## Inspector's Report 312162-21

Use of a weighbridge, wheel-wash, the erection of a staff office & administrative building, car park area, access road & improved site entrance, concrete and ready-mix batching plant, block yard & associated infrastructure.

Ballyonan, Broadford, Co. Kildare.

Kildare County Council

Figure 10.1: Noise Monitoring Locations at Ballyonan Pit. (source: www.google.ie/maps)

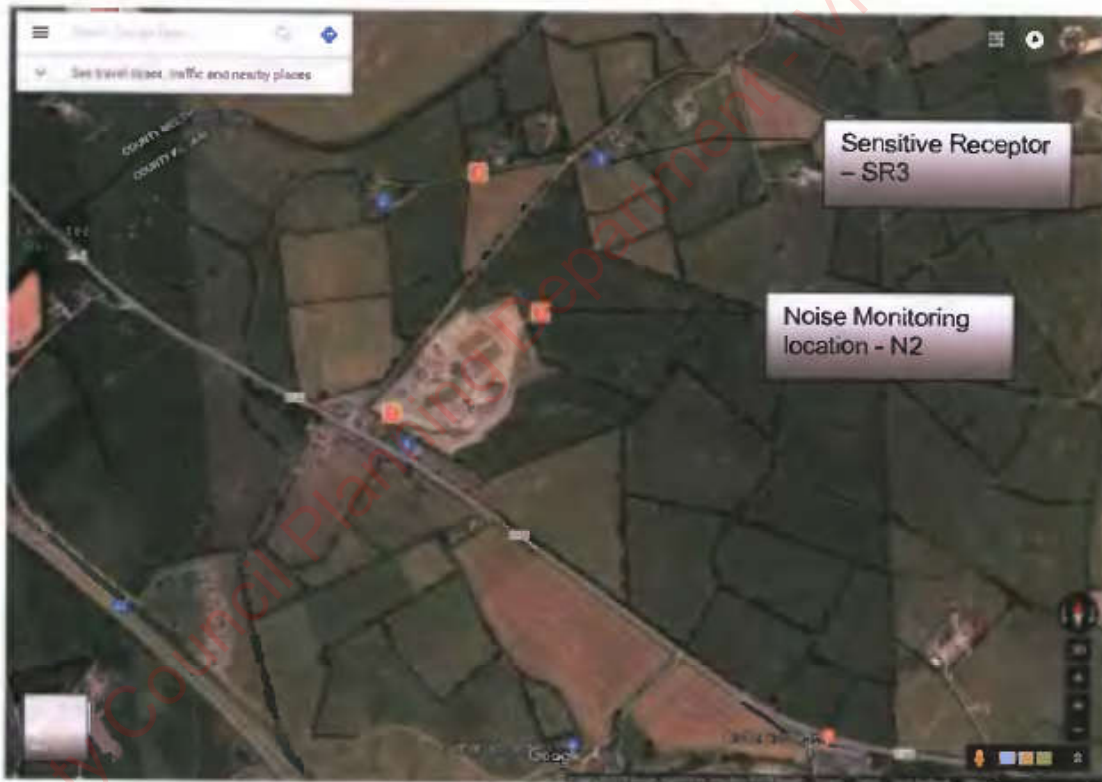
**(13)** The Planning Authority consider that the EIAR lacks adequate detail with regard to noise (items a – k).

- 3.2.30. **Item No. 13 (a):** The facility will not operate in conjunction with any other facilities or proposed developments in the area and therefore, there are no cumulative noise impacts. Existing noise levels at the site are compliant. Additional monitoring at noise sensitive locations was undertaken in September 2020. There is no proposed increase in traffic and no potential for additional road noise. The noise level 10 m from the L1011 when the existing site was not operational was higher than the measured level during the entire working day. Noise levels 10 m from the R148 are higher (62-63 dBA). The noise levels within the quarry are lower due to the topography of the site.

3.2.32. **Item No. 13 (b):** There are no 15-minute measurements in section 10.2 of the EIAR.

3.2.33. **Item No. 13 (c):** There is no inconsistency in the identified noise monitoring times and dates.
